STATE OF NORTH CAROLINA
DEPARTMENT OF TRANSPORTATION

Addendum No. 1

RE: Contract # C204244

Rowan County (I-5858)

STATE	STATE PROJECT REFERENCE NO.	SHEET NO.	TOTAL SHEETS
N.C.	I-5858	1	
STATE PROJ. NO.	F.A. PROJ. NO.	DESCRIPTION	
53061.1.1	NHPP-0085(019)	PE	
53061.3.GV1	NHPP-0085(019)	CONST

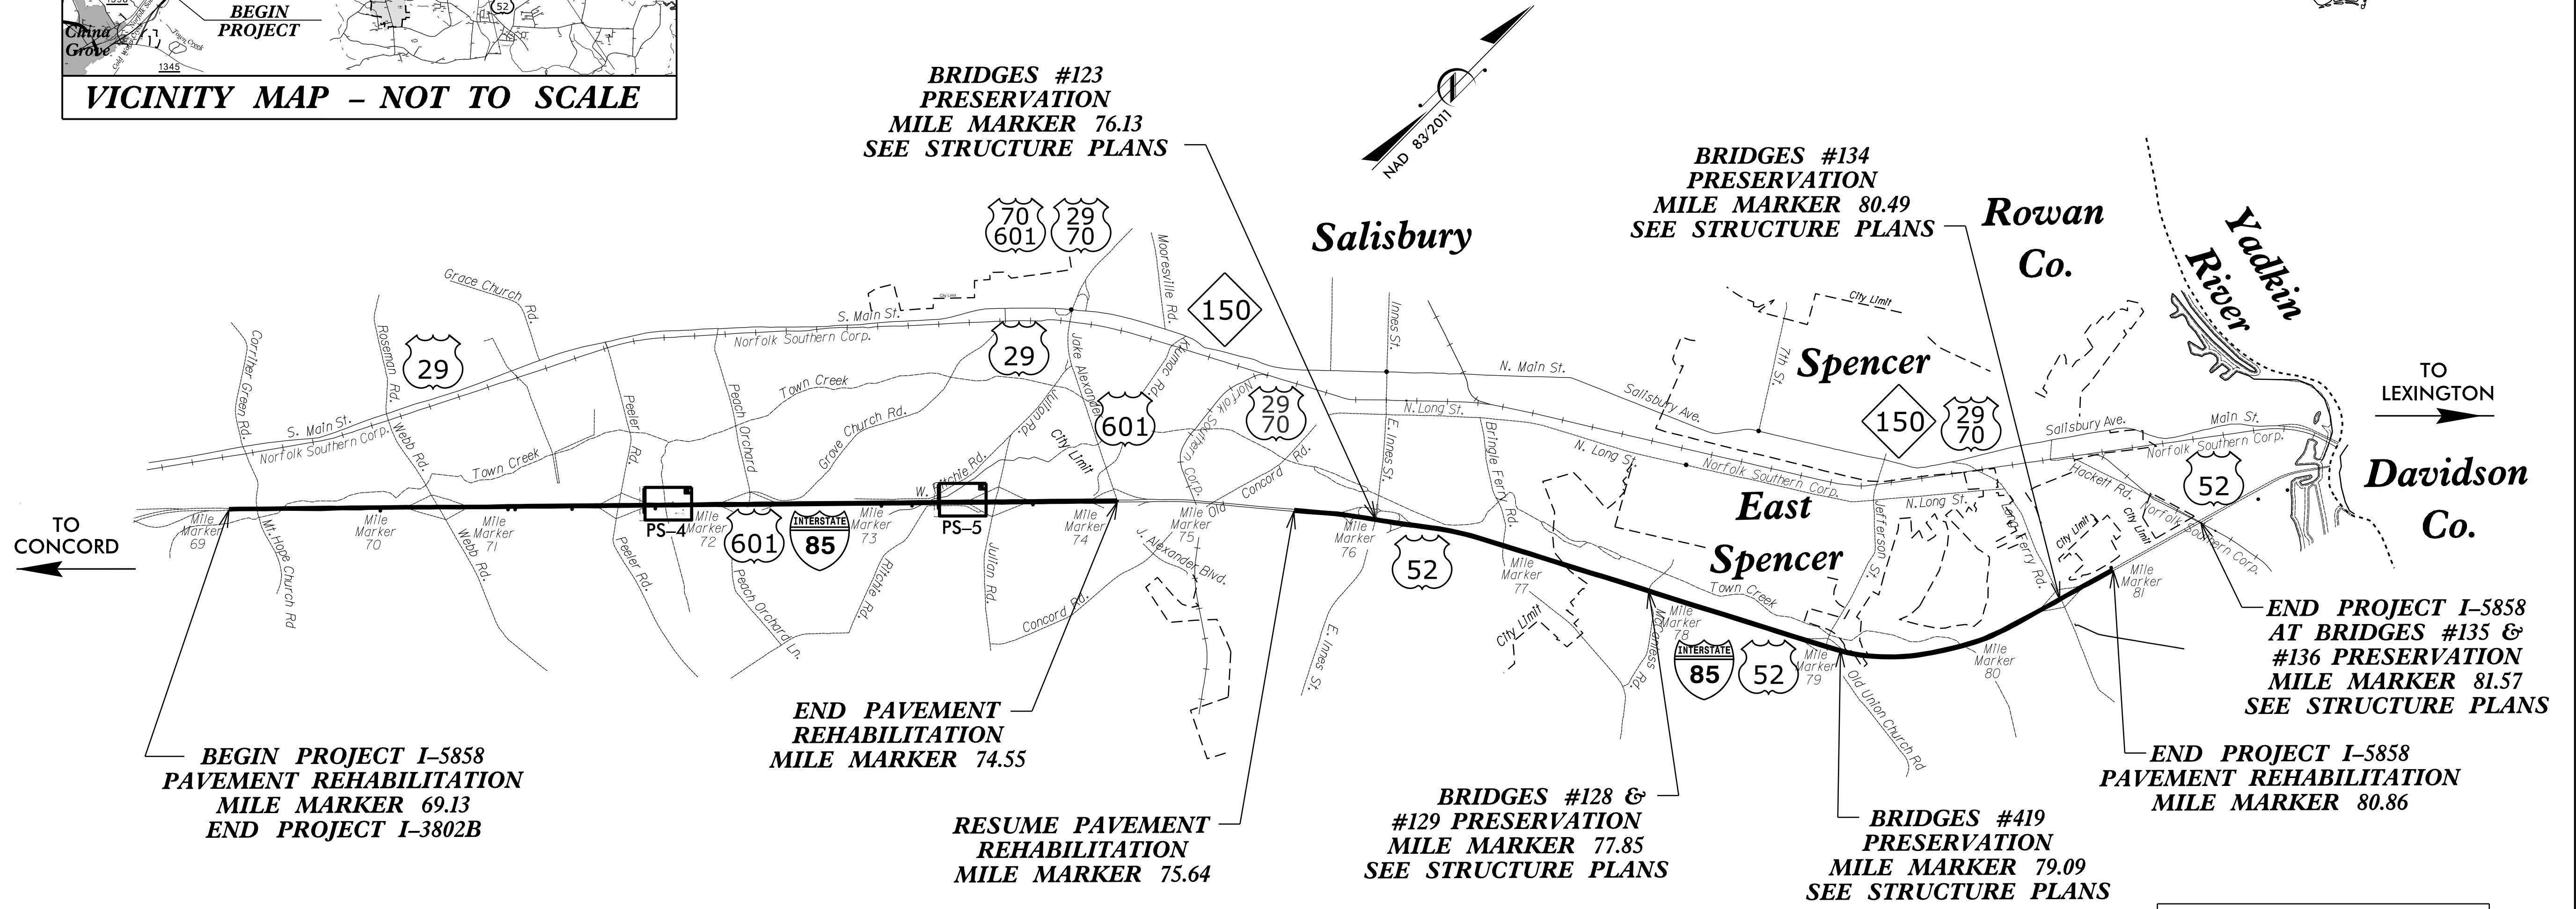
Sheet No.	Revision
1 (Title Sheet)	Revised to correct State Project number
1A	Revised to add SHEET NUMBER 2B-1 14" PCCP Slab Repair Detail
2A-1	Revised to clarify existing pavement depths
New Sheet 2B-1	Added sheet entitled SLAB REPAIR DETAIL FOR 14" PORTLAND CEMENT CONCRETE PAVEMENT
